**RE: Sundance Construction – Beverly Hills
Grading and Drainage Plan
Engineer's Stamp Date: 02/20/18
Hydrology File: B18D023**

Based upon the information provided in your resubmittal received 02/21/2018, the Grading and Drainage Plan is approved for Building Permit.

**RE: Sundance Construction -Beverly Hills
Grading and Drainage Plan
Engineer's Stamp Date: 01124/18
Hydrology File: 818D023**

This letter is in response to your comments by letter dated January 30, 2018. The comments have been addressed as follows:

A1 GRADING AND DRAINAGE PLAN

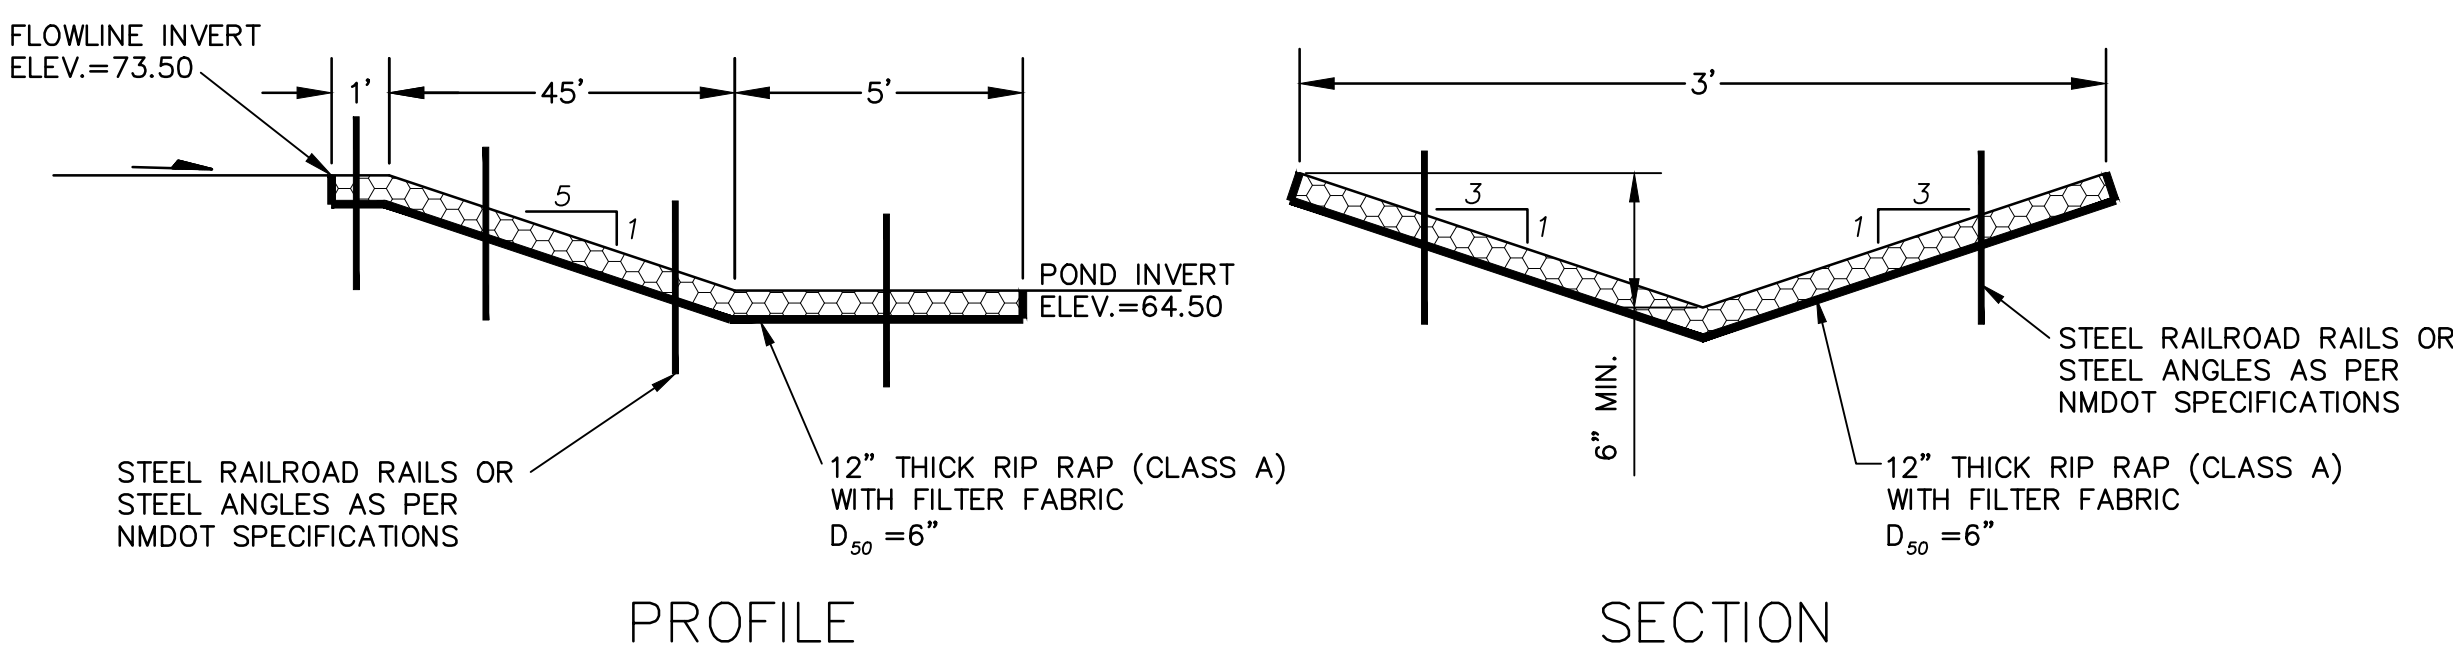
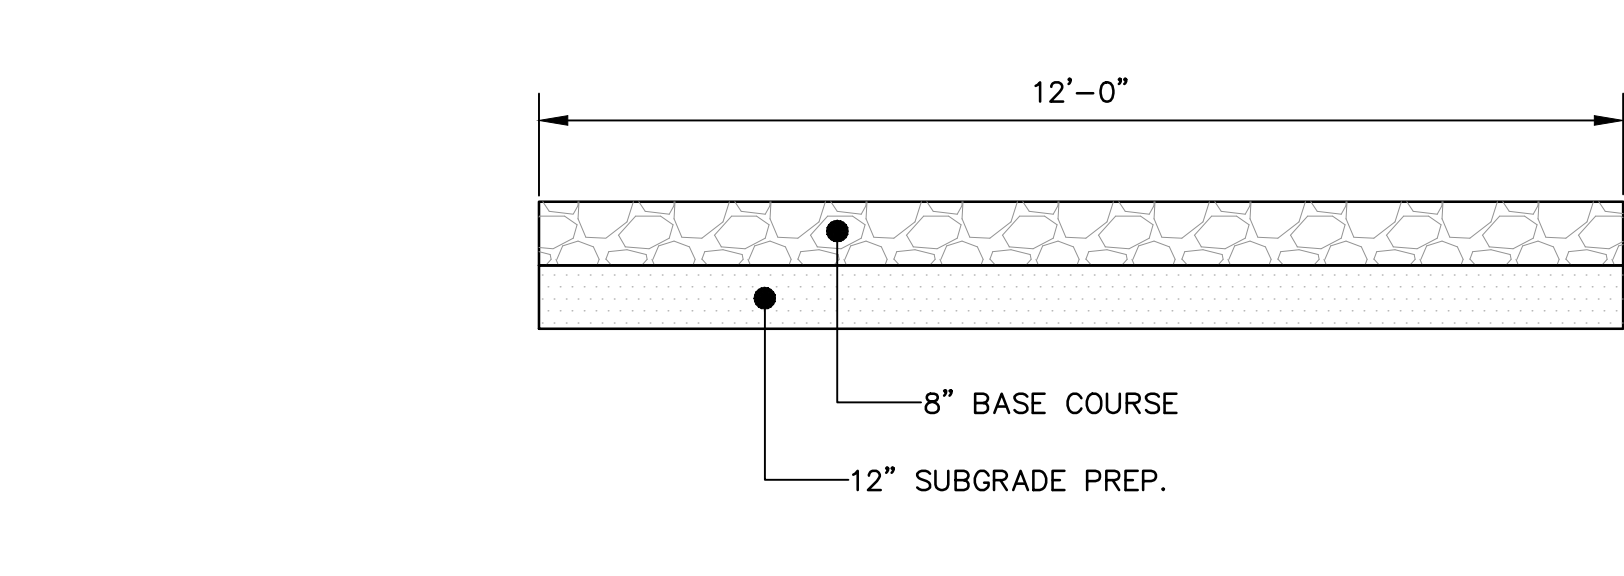
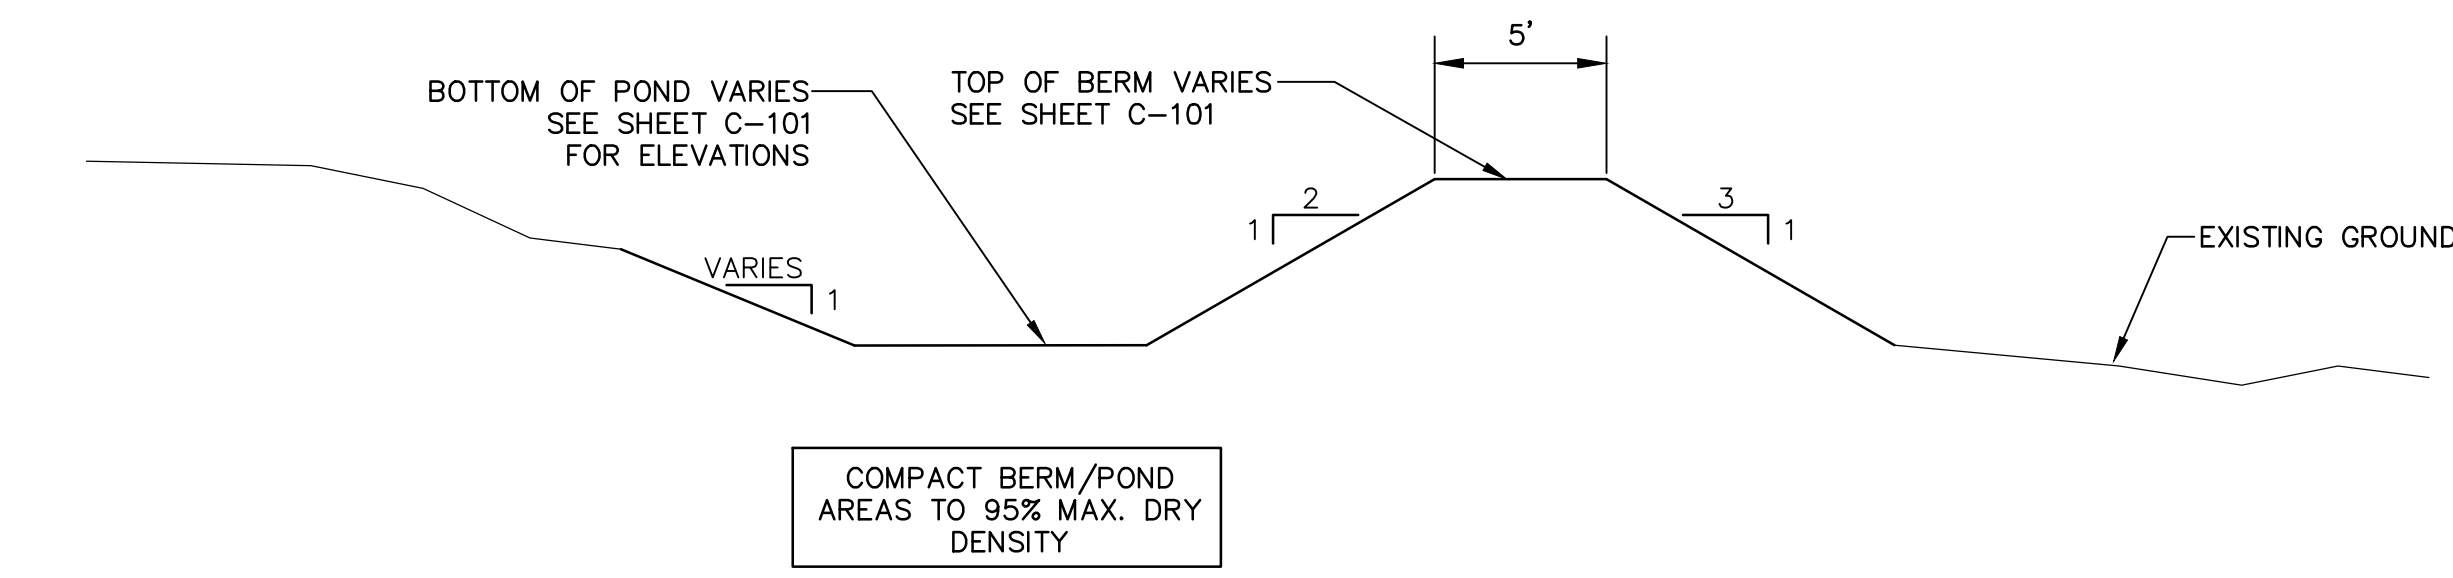
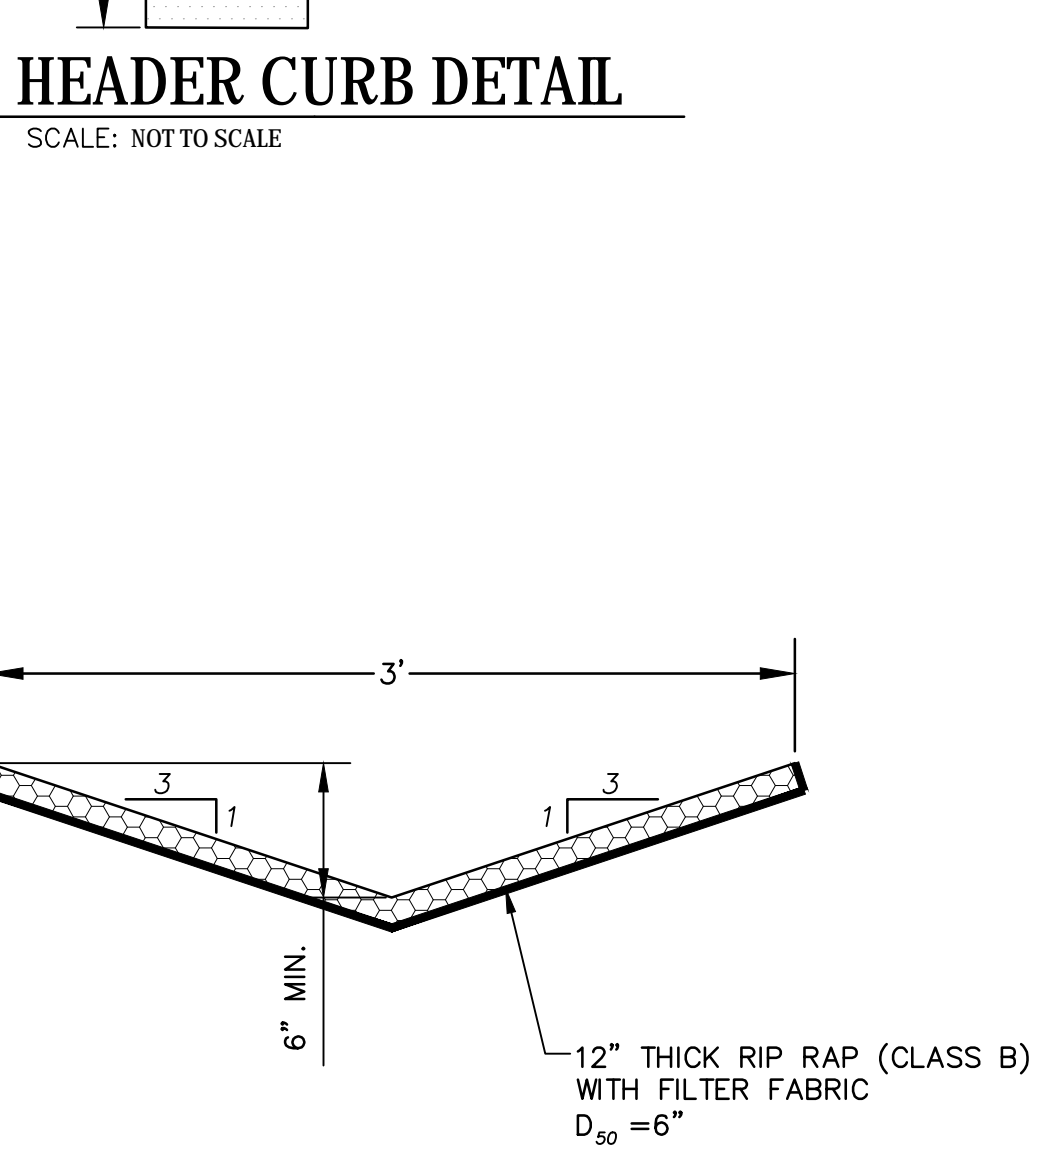
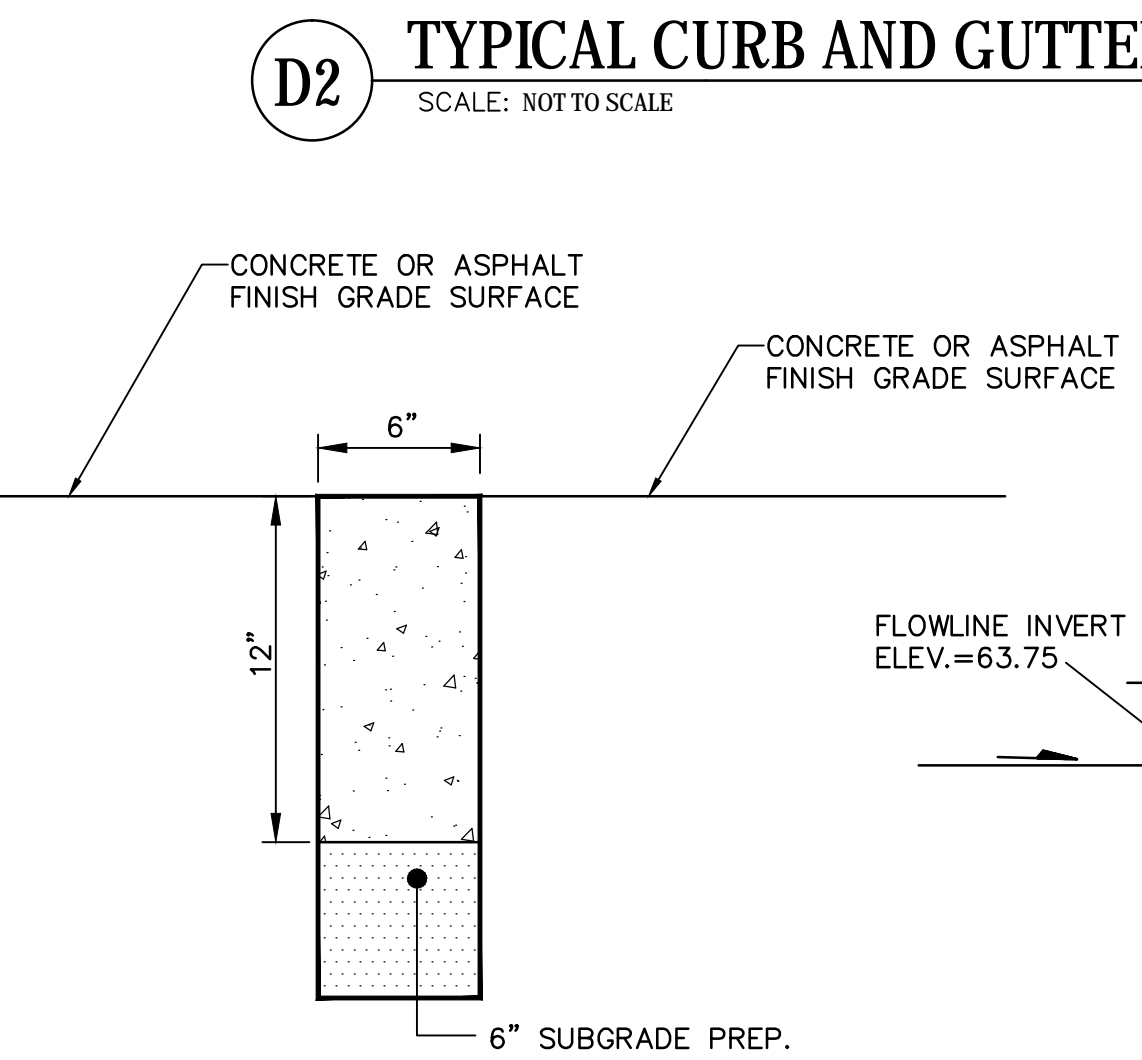
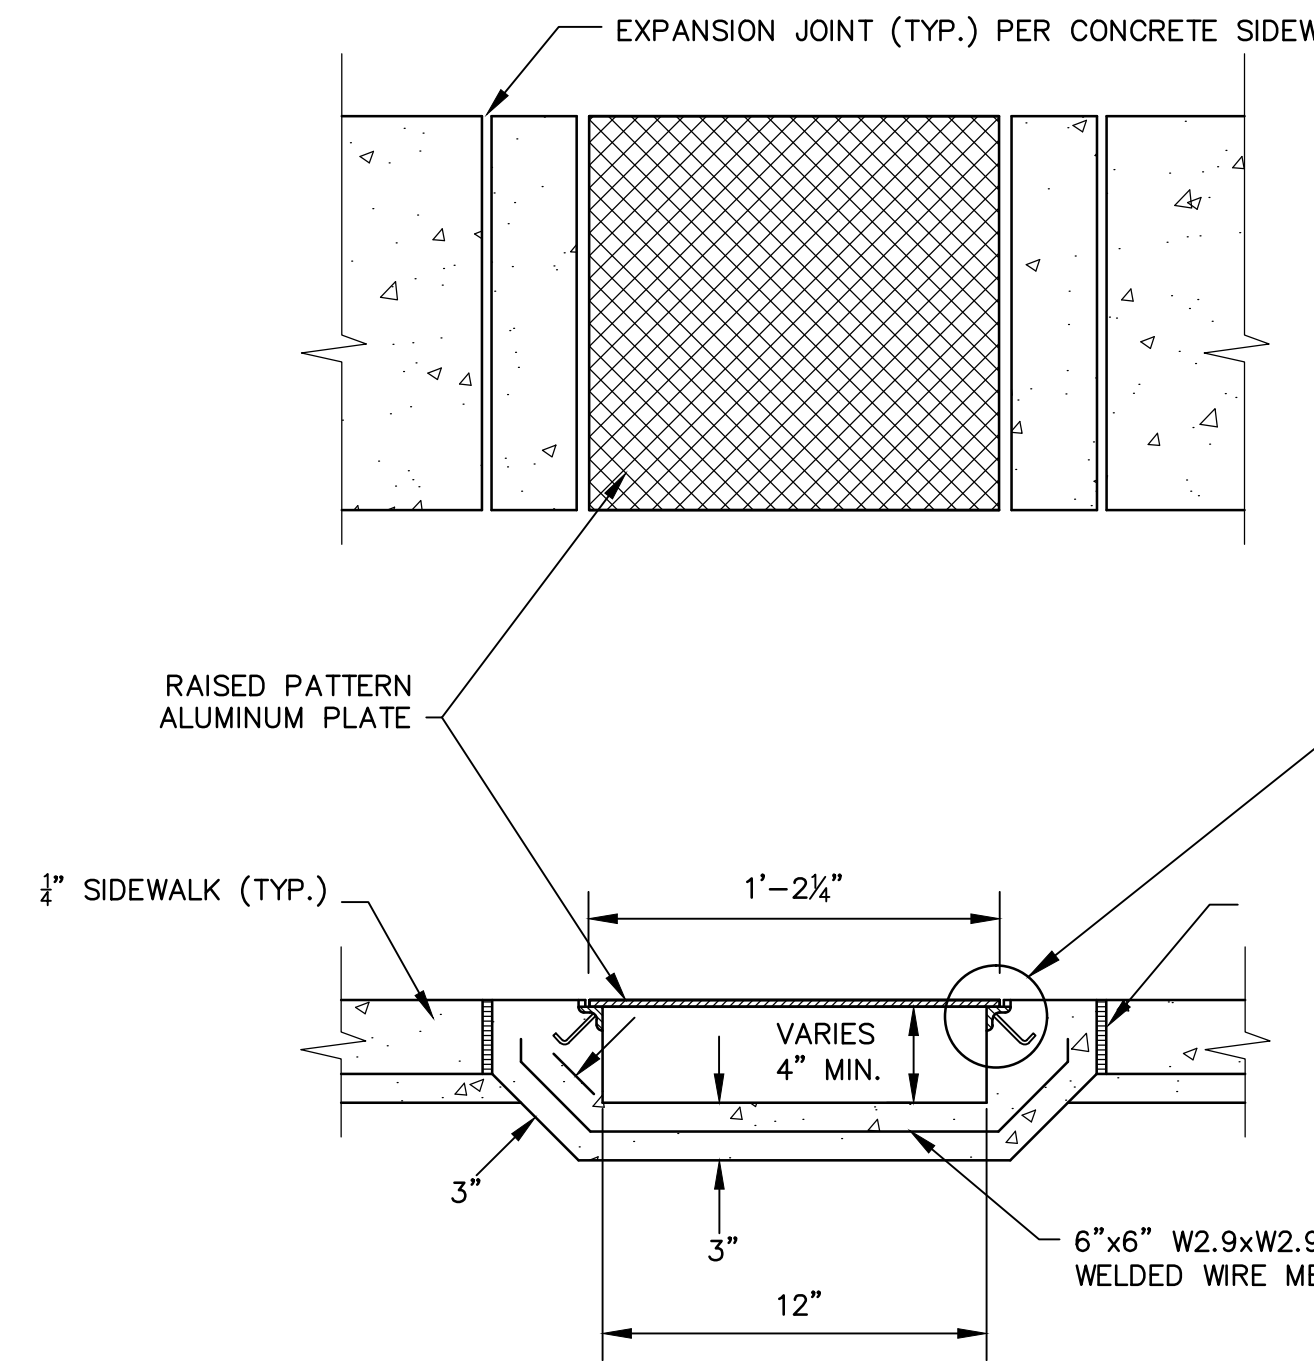
2. Key Note 7 states approximate location of property line. All property lines and existing topographic survey information must be accurate and not approximated. At the northwest corner, it appears that the adjacent pond is on this property. Please submit a surveyed property. If the property lines are properly surveyed, then delete the word approximate location of property line from Key Note 7.

3. Please provide a written agreement from Lot 28 property Owner stating that grading can be conducted on their property for the benefit of Lot 29. If an agreement cannot be obtained, then the swale to divert off-site drainage to Beverly Hills will have to be within the project's boundary.

4. Please add the flowline information at the start of the diversion swale at the east side of the property.

5. Key Note 22. This pond is just pointing to an open area. Is there supposed to be a first flush pond here?? It appears that all first flush volume is included in the pond to the southwest corner of the property.

8. Please show the half street, storm drain, and inlet which is to be constructed with the work order. Please add a note that all work within Beverly Hills Ave will be part of Work Order #722084.

See sheet C-101.

IN PROCESS.

See sheet C-101.

See sheet C-101.

See sheet C-101.
